Application No: AW/81/21/HH
Site Address: 2 Old Farm Close Aldwick PO21 4AX
Description of works: Two storey extension.

Thank you for your internet representation made on 7th April 2021 which has been recorded as an objection with the comments as follows:

OWPC34972

Proposed second floor plan 1:100

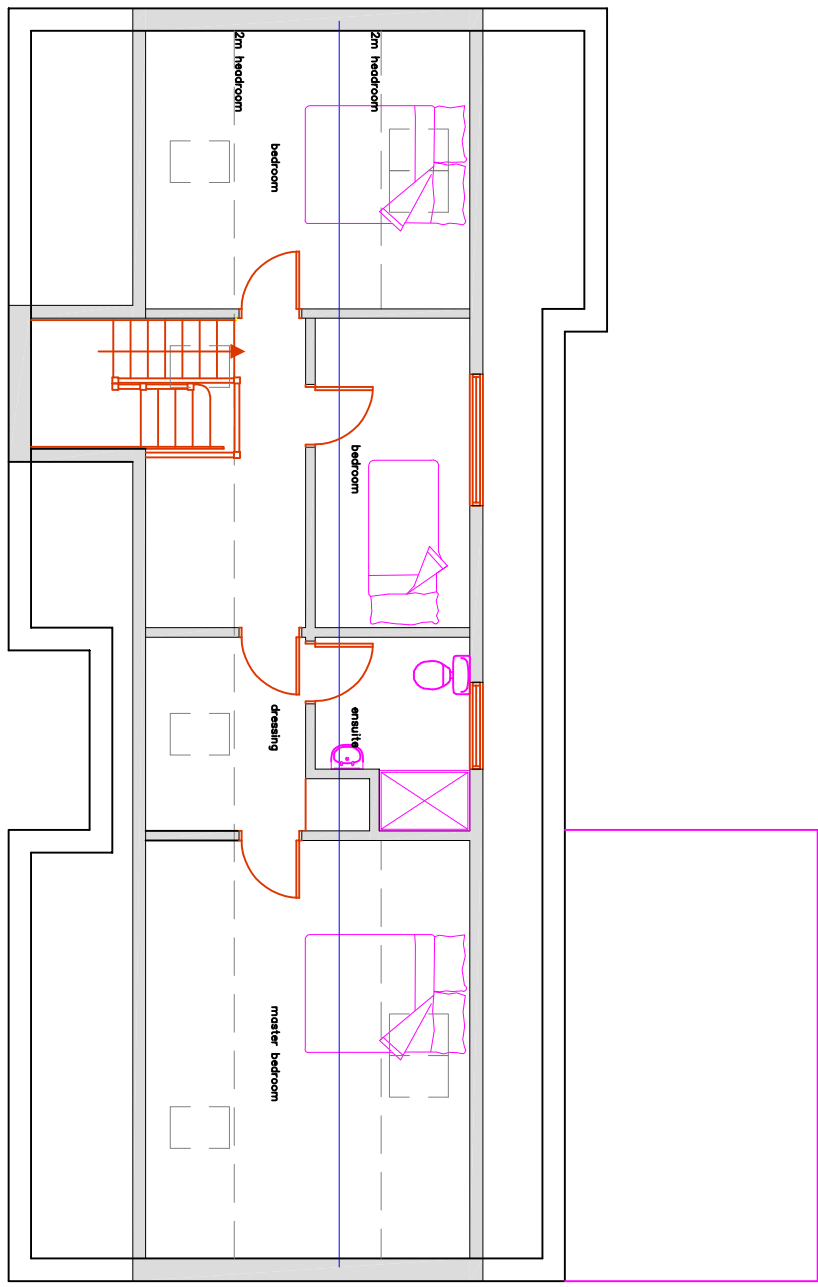
1. Size: The proposed plan would increase the house frontage by some 50%.
2. Bulk: The proposed plan would increase the internal floor area by over 100%.
3. Outlook: The proposed design shows Dormer windows in the roof at the rear of the property which would overlook at least 5 adjacent properties,
4. Garage/Off street parking: the proposed plan makes no mention of garaging and suggests off street parking for only 2 cars, which would seem inadequate for a house with 9/10 bedrooms and sleeping capacity for up to 17 people.
5. Un-neighbourly: The proposed changes would create a property which would be out of character with the neighbourhood because of its Size, Bulk, and design. It would overlook its neighbours and interfere with traffic
